March 29, 2010

**Re: Minor Site Plan Review: 231 York Street; Demolition of existing building and construction of new building for restaurant use**

**Site Plan Application # 09-79900017**  
**CBL: 044-E-003-001**

231 YORK STREET PORTLAND, MAINE
 SOUTH ELEVATION PROPOSAL
 1/4" = 1'-0" 3/8/10

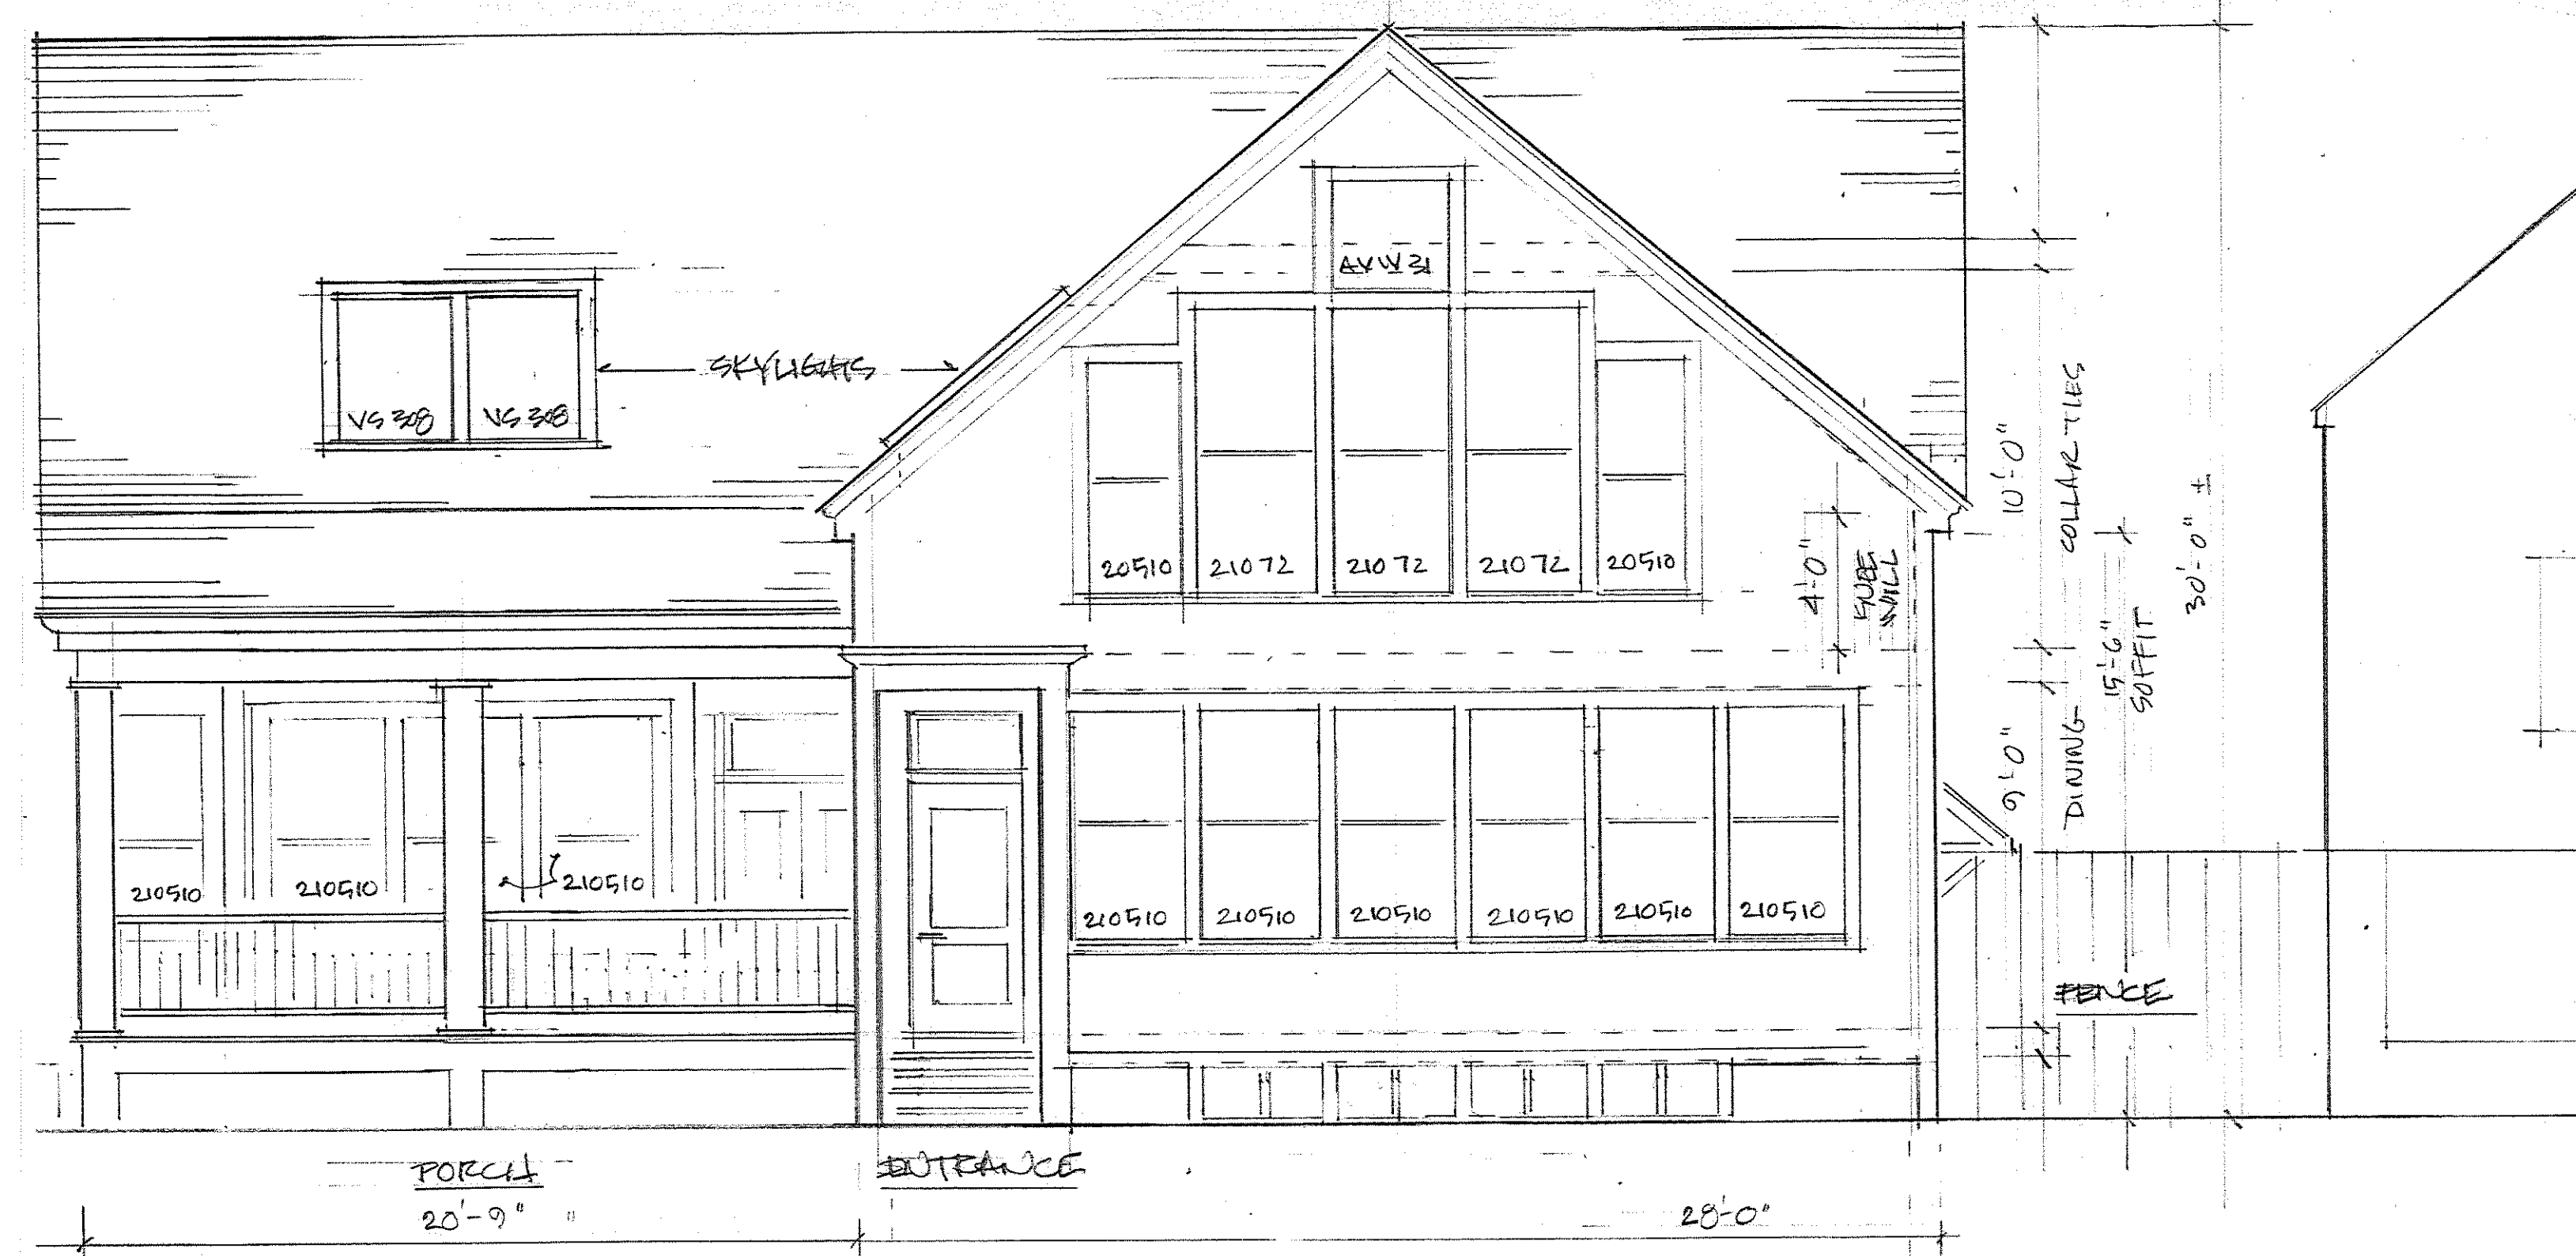
2. Zoning:  
Information regarding the rated noise levels and compliance with noise allowances is awaited.
3. Mechanical Plant:  
The set of plans submitted March 9<sup>th</sup>, 2010 are the first to show the proposed roof and porch mechanical plant (understood to be 4 vents and 2 HVAC units on the roof (all facing towards the residential neighbors) plus 2 condensers and some compressors on the rear-facing equipment porch. The City's ordinance is the context for the review and the B1 zone has a purpose statement that includes:

In summary, there are two issues related to the location, size and number of these units:

- a. **Noise:** The number of noise-generating roof and porch plant on the rear side of this building raises questions of the noise generated by each unit, the cumulative noise and the period of time over which they will be making a noise; and
- b. **Compatibility:** The B1 design standards require *"...commercial buildings shall be designed to be compatible with their residential and commercial neighbors... building scale, roof pitch, and fenestration shall be designed to complement surrounding residential structures."*

While we appreciate that this use does require some mechanicals, given that this is limited to 1000 sq ft we would like information/clarification regarding why so many are needed, why they need to be at this scale, and whether any could be relocated within the envelope of the building or on the side of the building. As requested, I confirm a meeting has been arranged to discuss these questions on **Monday April 5<sup>th</sup>, 2pm.**

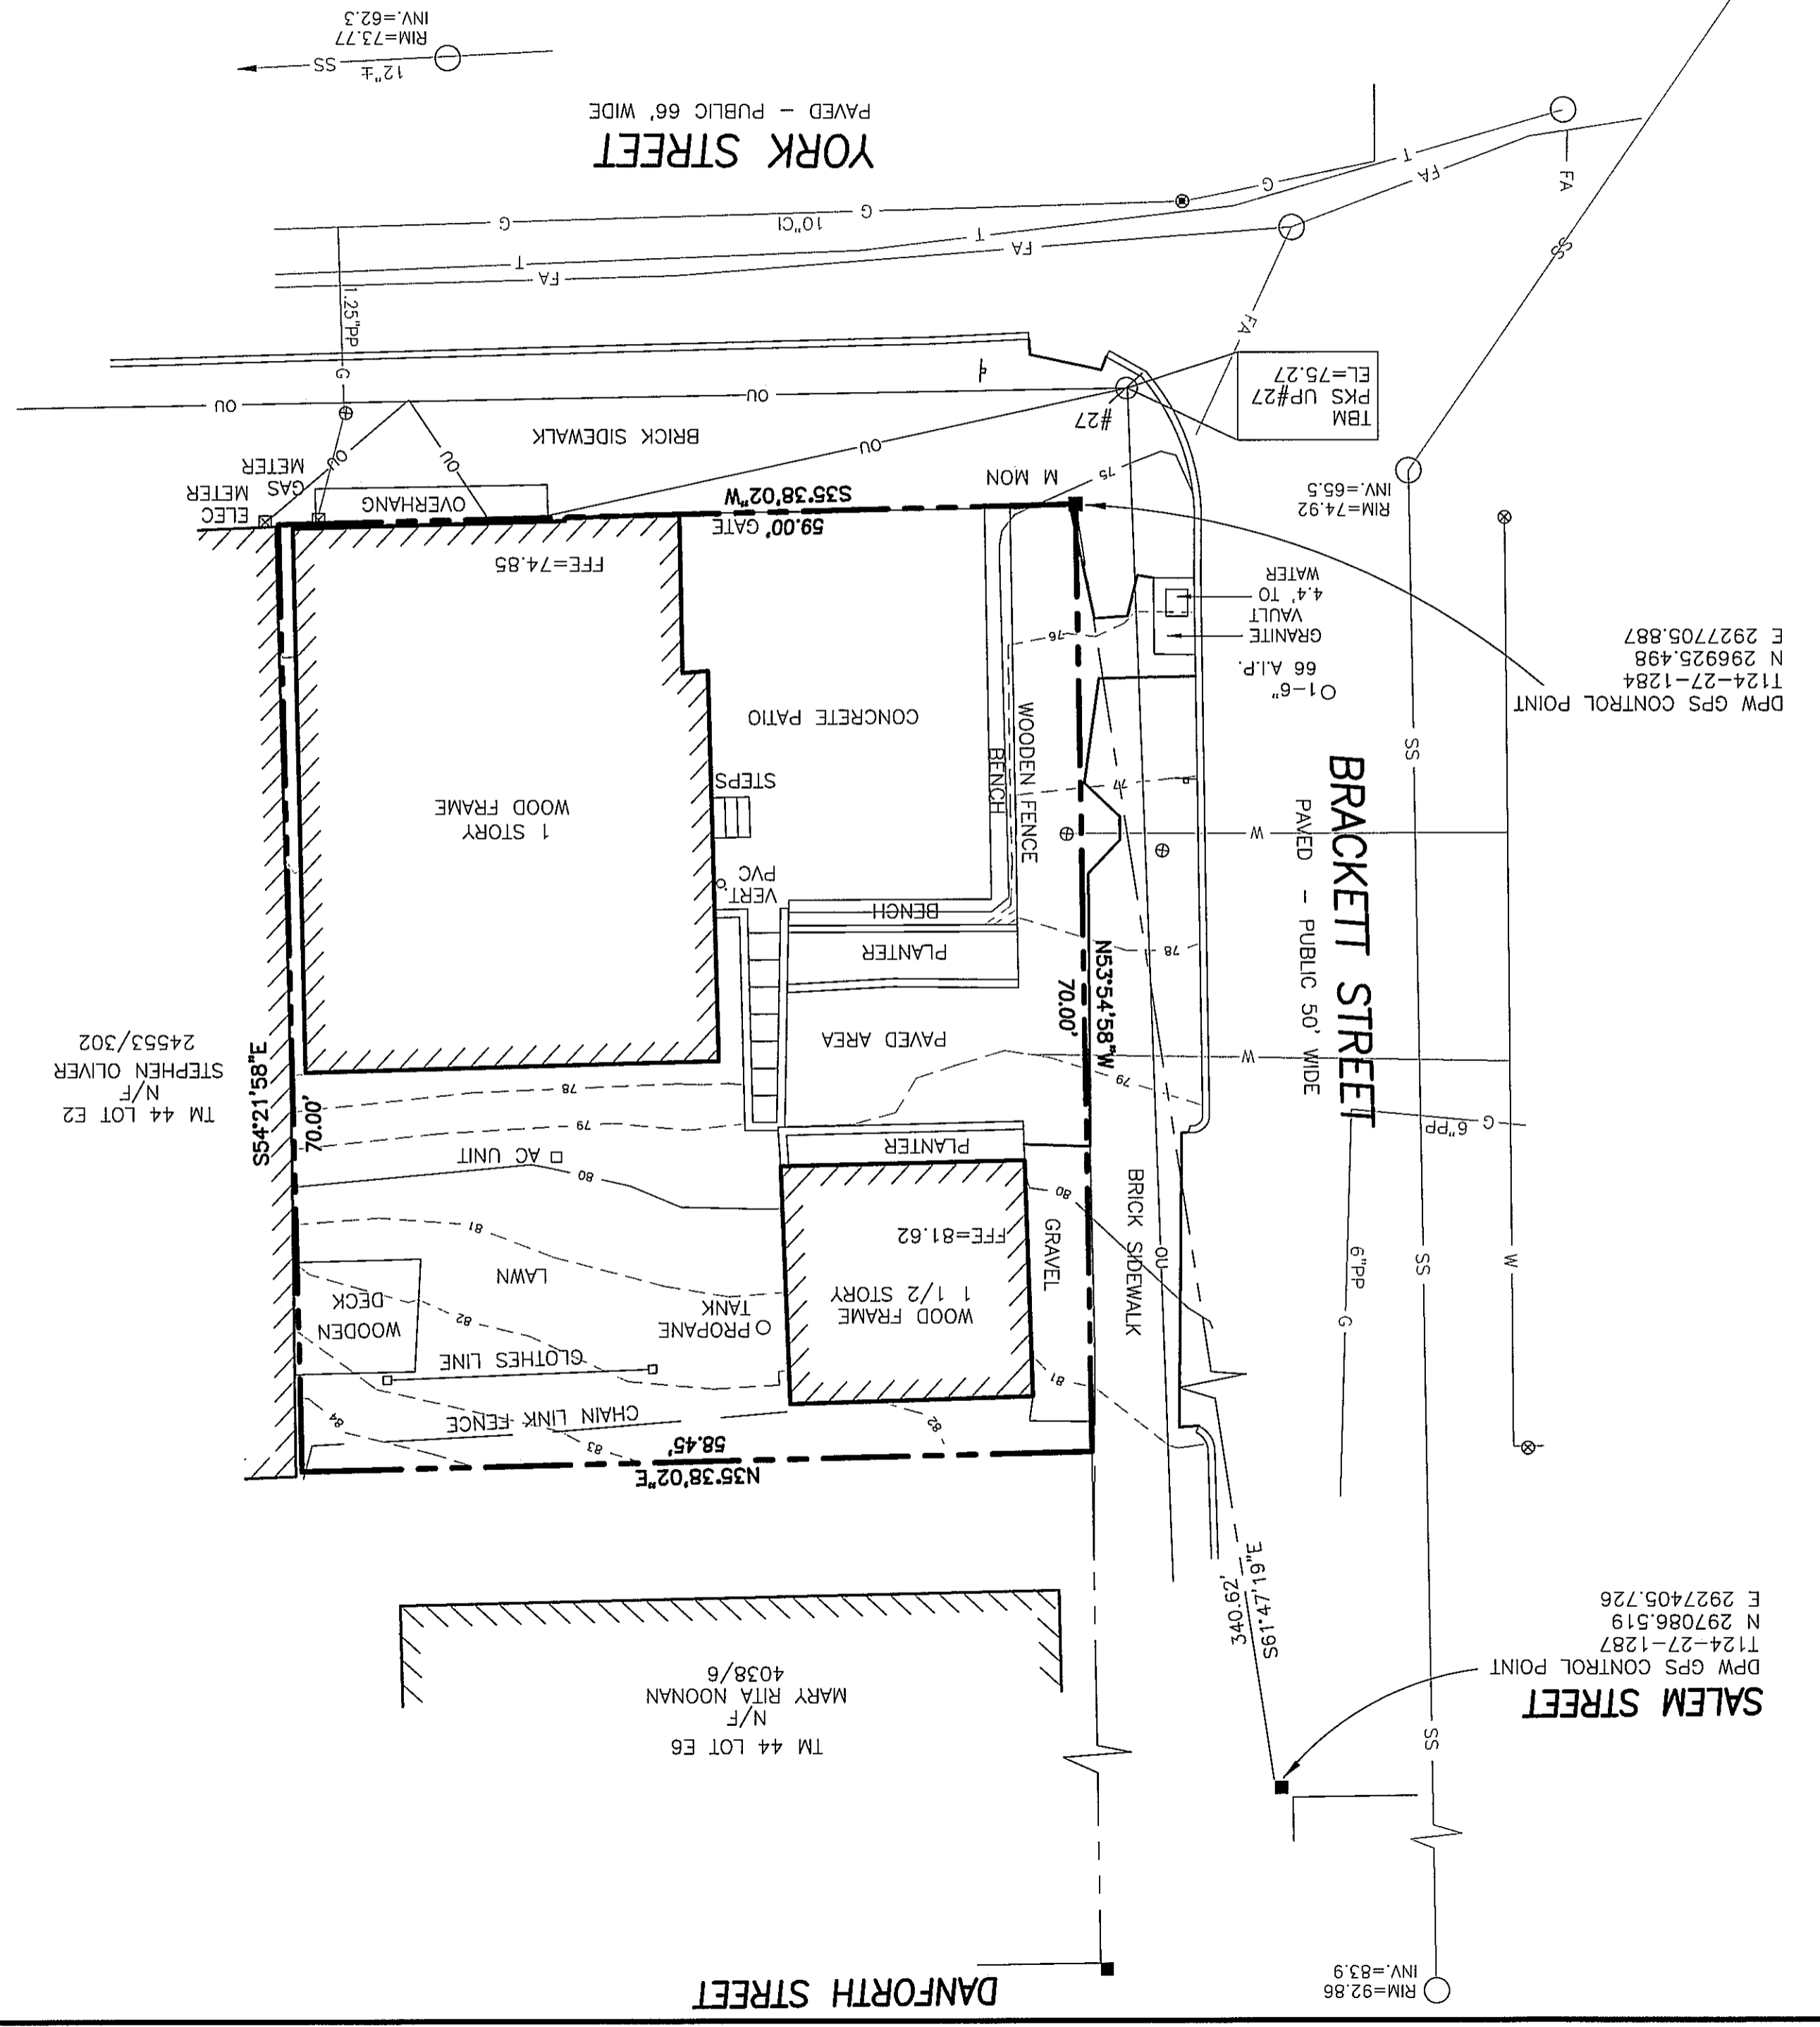
1. Survey:  
Sheet 2 shows an existing street line M Monument to be reset. The City suggests that the note be changed to set a new monument at the street line with a three foot offset corner as per City of Portland Technical Standard Detail for Granite Survey Monuments (see detail in Attachment 1). The Department of Public Services will supply a 5/8" copper bolt and brass survey washer to the surveyor who will mark the new monument. It is also suggested that survey pins be set at the property corners; this may be a condition of approval.
